Department of Primary Industries

OUT17/21925

Flyers Creek Wind Farm (MP 08_0252 MOD 3) Comment on the Environmental Assessment (EA)

FIGURE 7.8: Potential Water Crossings North

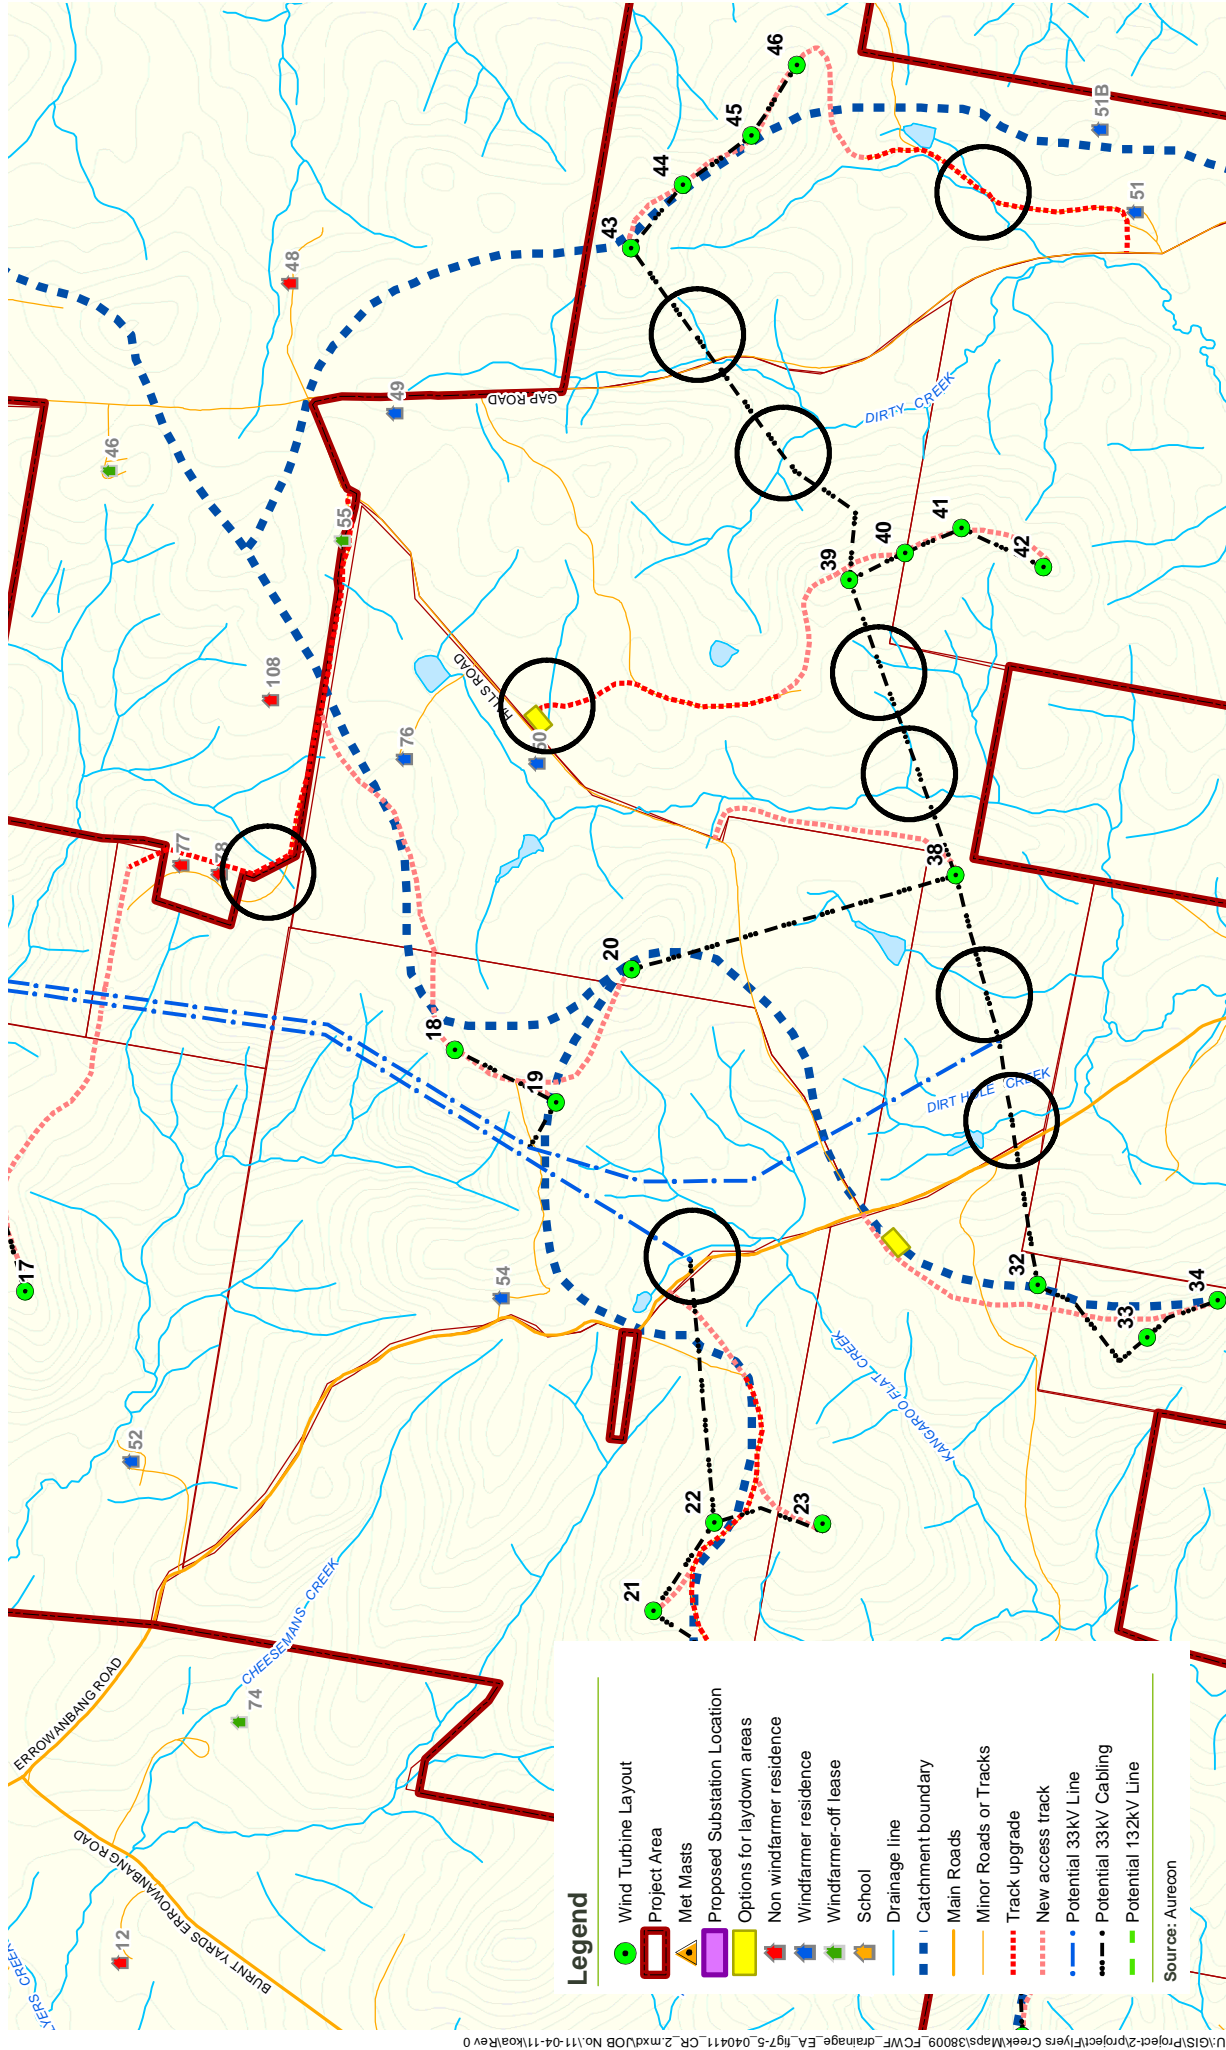
- It is likely that the works proposed in the modification will require new watercourse crossing, but it is not clear in the EA where these crossings will be located. The proponent should detail where watercourse crossings will be required, and ensure that all works undertaken within watercourses, or on waterfront land, are done so in accordance with DPI Water [Guidelines for Controlled Activity on Waterfront Land \(2012\)](#).
- The proponent should consult with Department of Industry – Lands and Forestry (lands.ministerials@industry.nsw.gov.au) on possible impacts to Crown land Lot 7002 DP 1019823, and Crown road and Enclosure Permits 20108 and 20112.
